CITY OF ALBUQUERQUE

December 13, 2011

Re: Spectrum Assisted Living, Grading and Drainage Plan
Engineer's Stamp dated 11-21-11 (A12/D025)

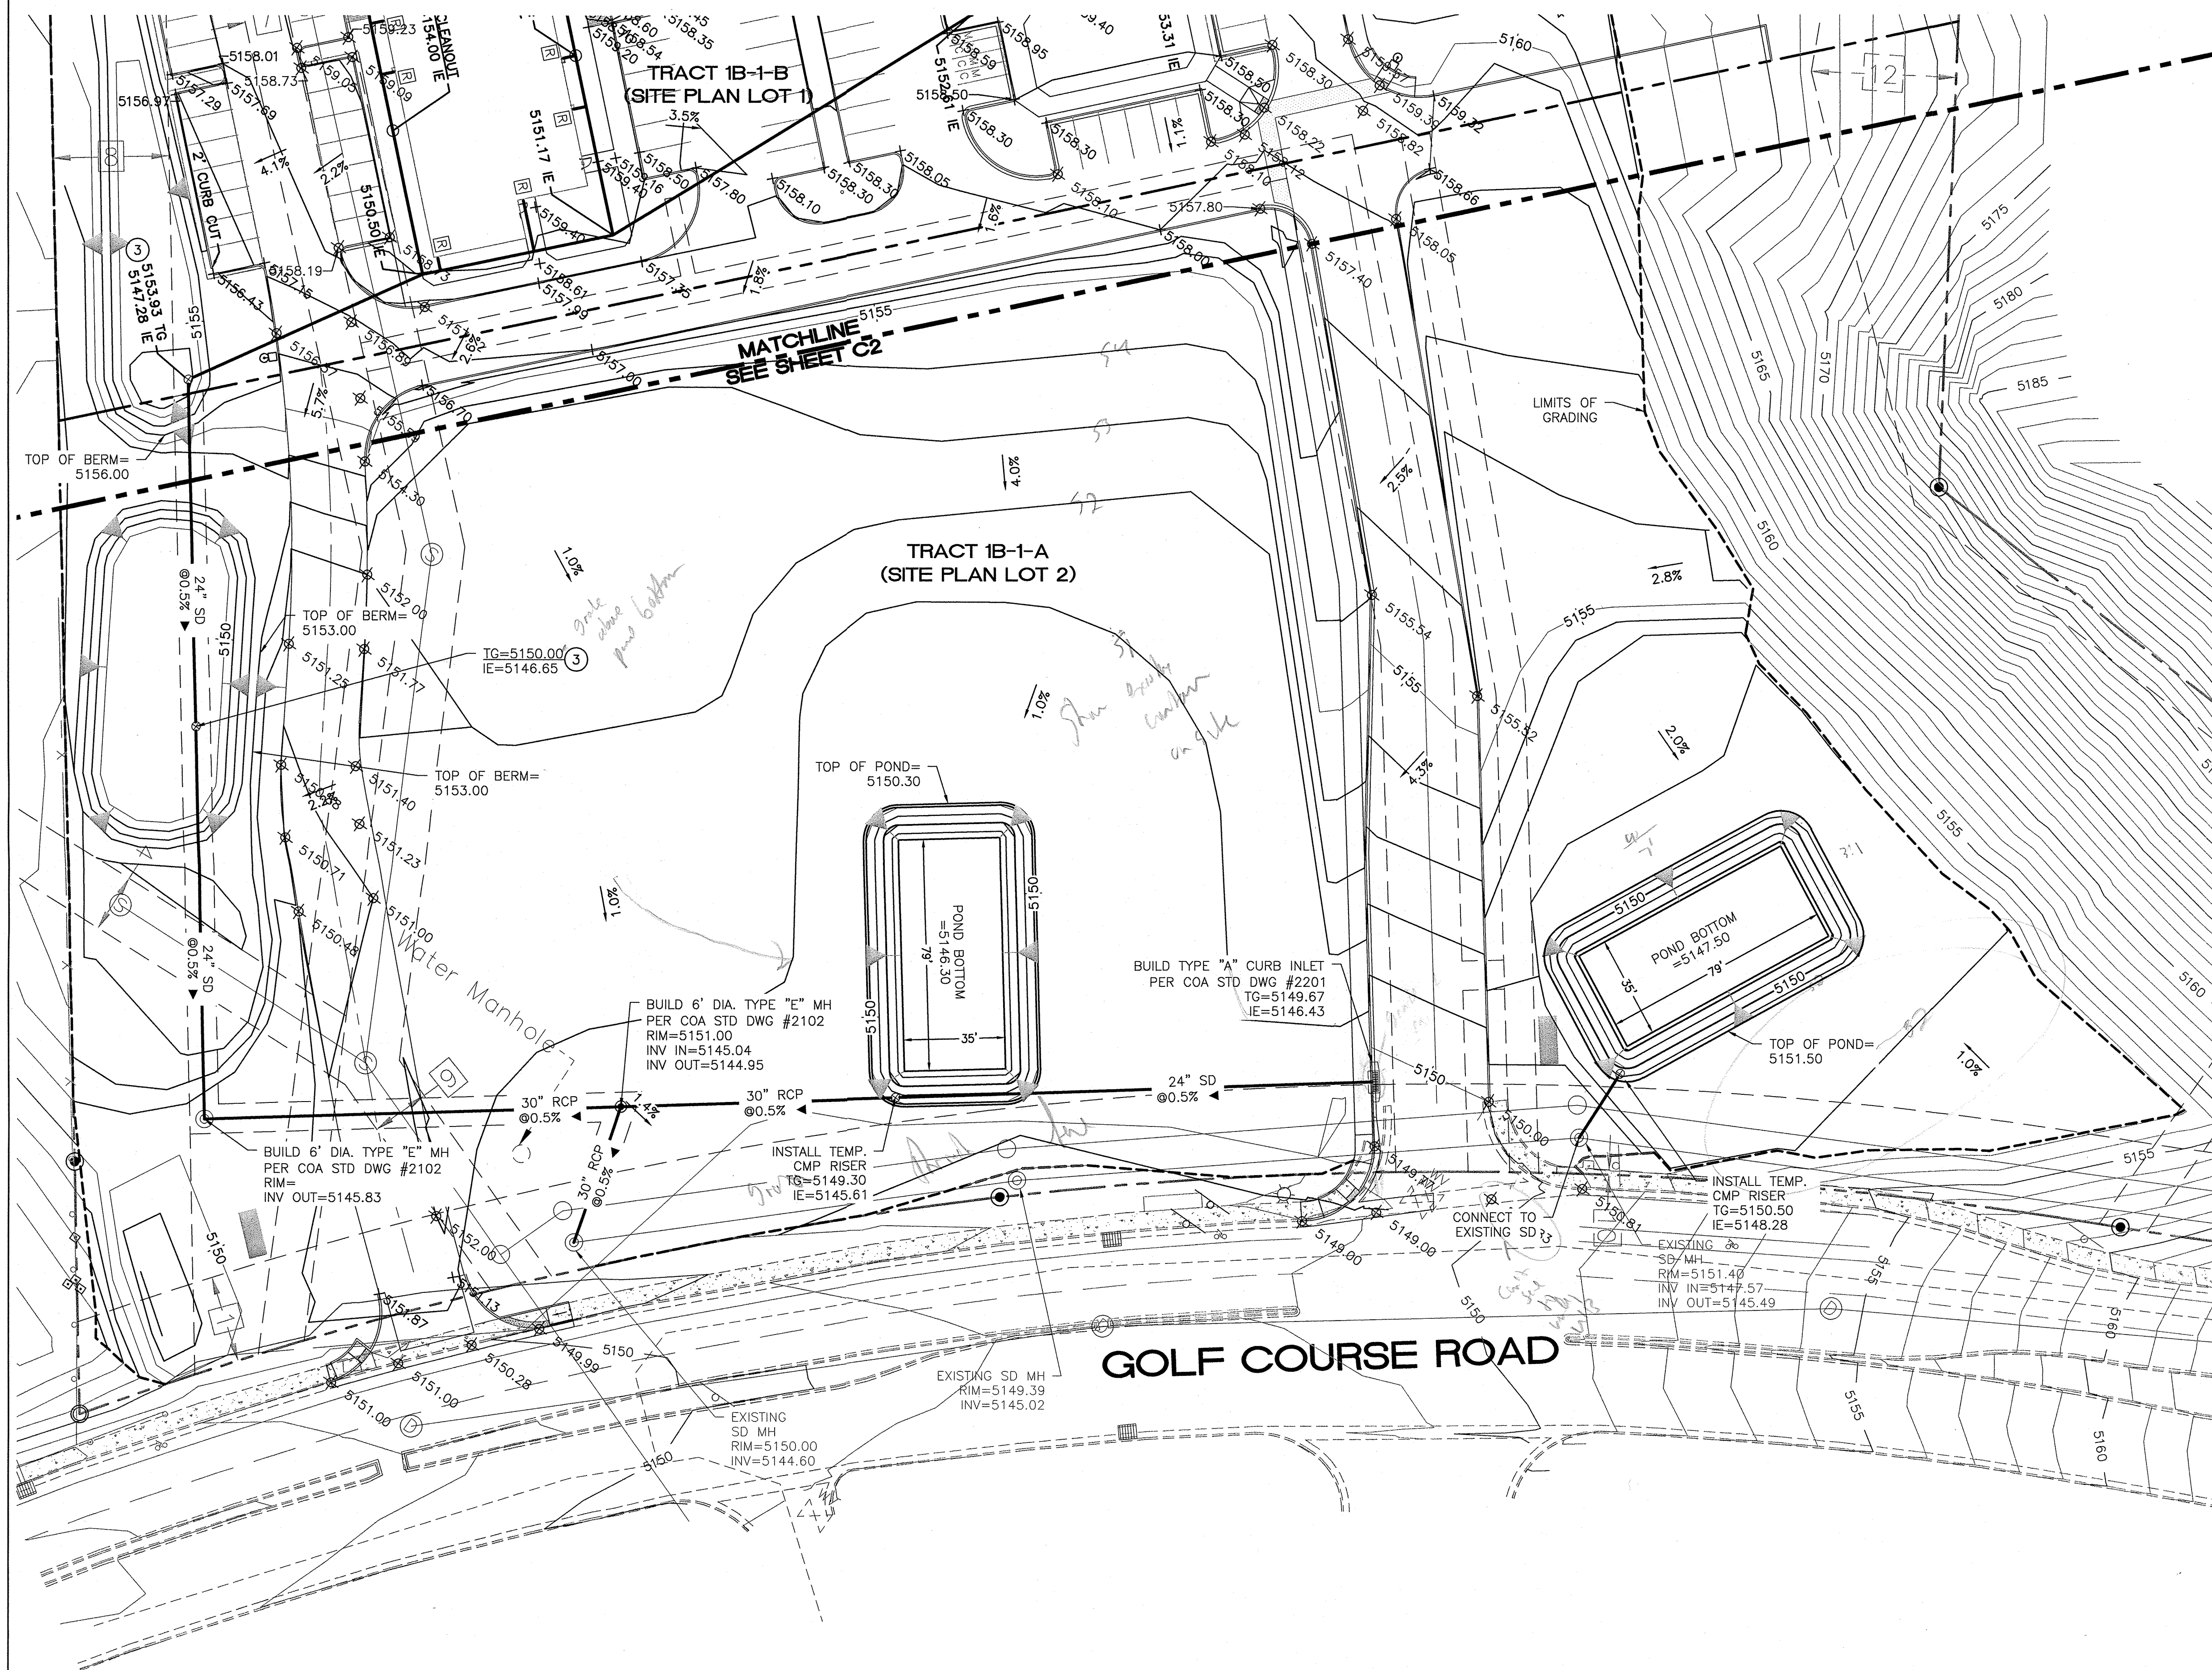
- Provide existing spot elevations around the perimeter at regular intervals as well as inside to support existing contour data.
- Provide existing contour data (legend?).

- Provide numerous (similar to the top of sheet C3B) proposed spot elevations in the parking/drive areas as well as near the buildings.
- Provide grades in west courtyard area of large building.

- Provide direction of roof flows, except the building with roof drains.
- It is not evident that the area behind/along buildings will drain.
- Show high points/basin divides with spot elevations.

- To accomplish stormwater quality and to prevent inlets from being buried, the inlets in the water harvesting ponds along the arroyo should be elevated above pond bottom. How high should they be elevated to accomplish these goals?

- Do the areas west of Golf Course Rd. drain to the sedimentation ponds? It is very difficult to tell in Basin 4.
- Hydrology could not find the benchmark information.

- The flow line elevation at the north entrance is covered with text.
- The slope near building FF 51761.7 and FF=5163.5 appear to be steeper than 3:1. *building in outer space?*

- Steep slopes near the property line could affect neighboring properties. Provide proposed spot elevations at the top and toe. Will these areas be revegetated?
